Application for Works to Trees(s) subject to a Tree Preservation Order(TPO)

Development: To reduce 3 No. Maple Trees lateral branches, which are overhanging garage by 1.5 metres.
To reduce 1 No. Oak Tree lateral branches, in rear garden on right hand side by 1.7 metres.
The reason for the works is these are clearance of garage and patio area.

Location: 4 The Spinney Aldwick PO21 3RL

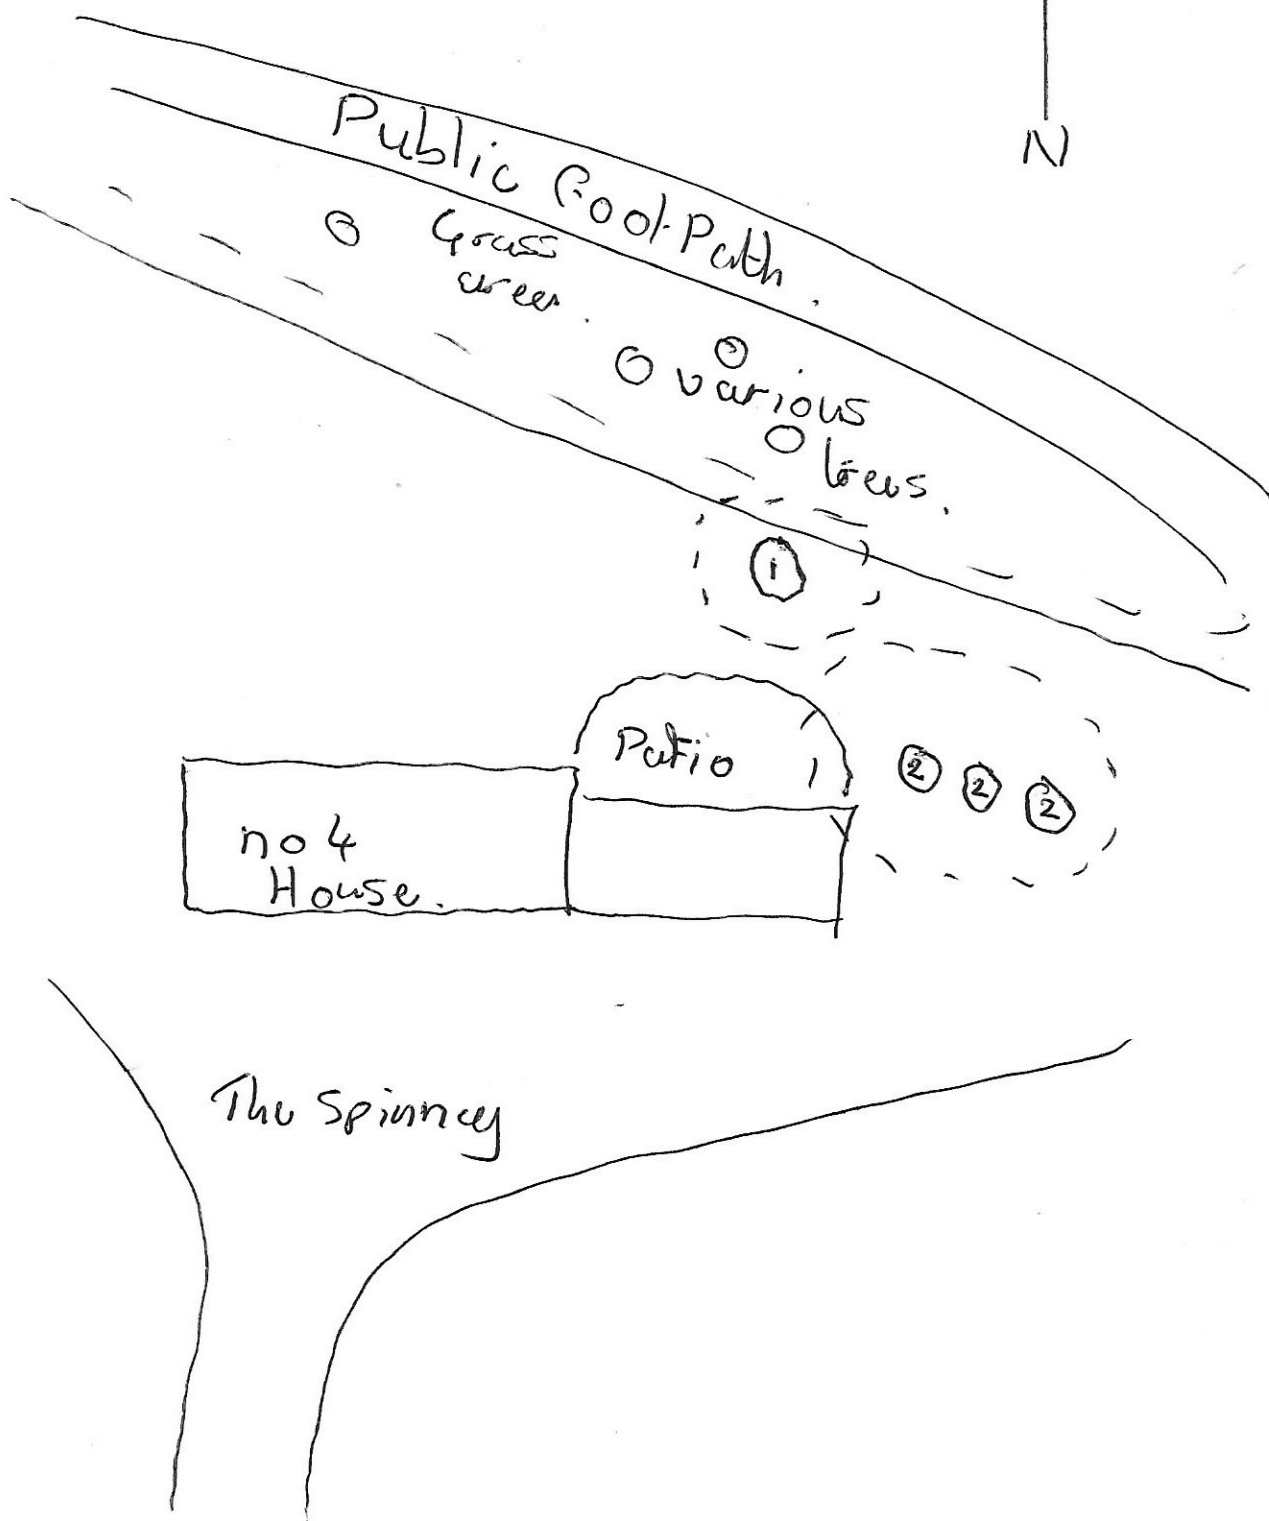
Please provide proposed spread measurements(m) of 3 No. Maple Trees and 1 No. Oak Tree and clarify location of trees on Sketch Plan provided.
